The Keadby 3 Low Carbon Gas Fired Generating Station

Planning Inspectorate Ref: EN010114

Statement of Common Ground with the Environment Agency

Date: February 2022

Indicative Layout
Proposed PCC Site

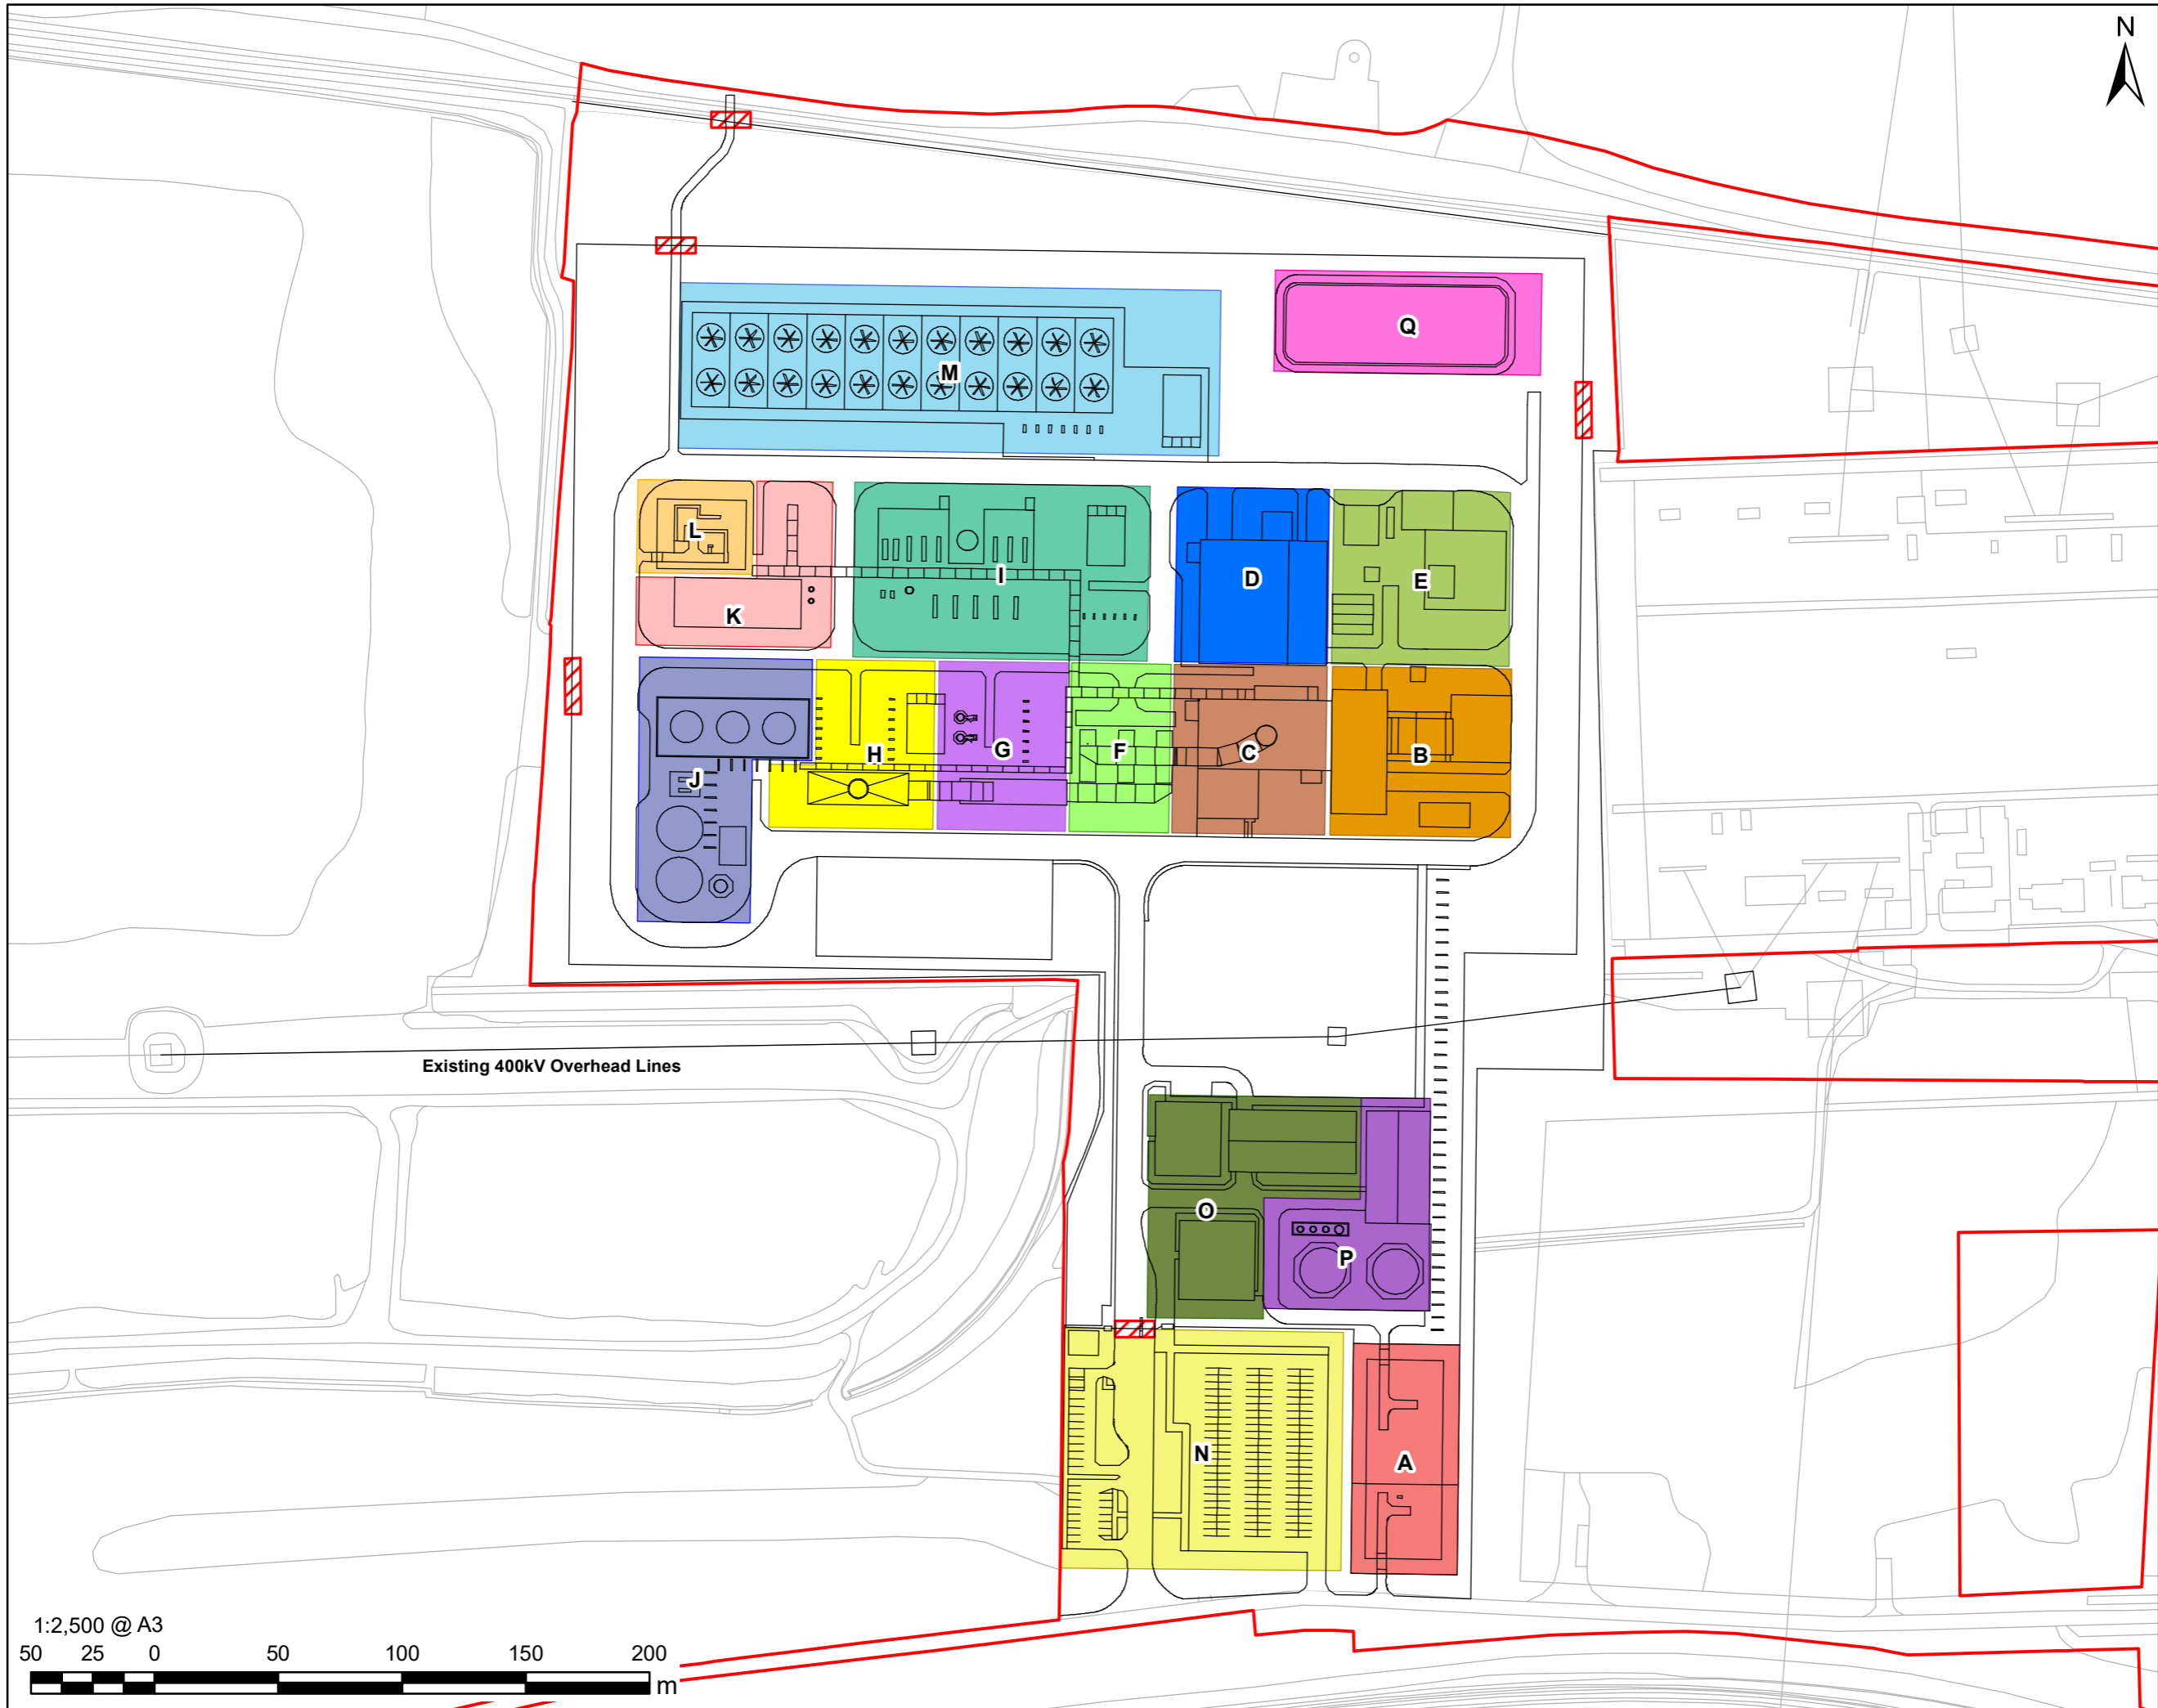
C1 - Design, Planning Permissions and Approvals	The Applicant needs to update the site plan to clearly show the location and extent of the 6.55Ha of land set aside for the CCP.	Appendix A drawing 60625943-CCR-DR-02 Rev B shows the location and extent of the 6.55 hectares (ha) of land set aside for the CCP. The Works Plans accompanying the DCO application (APP-012) clearly set out the area allocated to the CCP.
C2 - Power Plant Location	The Applicant needs to identify, on the site plan, the CO2 pipeline within the plant and the exit point from the curtilage of the plant	Appendix A drawing 60625943-CCR-DR-01 Rev B shows indicative CO ₂ pipeline route, from the CO ₂ compressors to the Proposed Development Site boundary. The connection to the CO ₂ transportation pipeline is at or within the Proposed Development Site boundary and it has been confirmed by National Grid Carbon that the Humber Low Carbon Pipeline (HLCP) will run to the Proposed Development Site to facilitate the connection. The Proposed Development will connect into the HLCP and the East Coast Cluster. National Grid is consulting on the final route of the HLCP as part of their DCO application which is being prepared and will be submitted for examination in 2022. Maps of the likely route
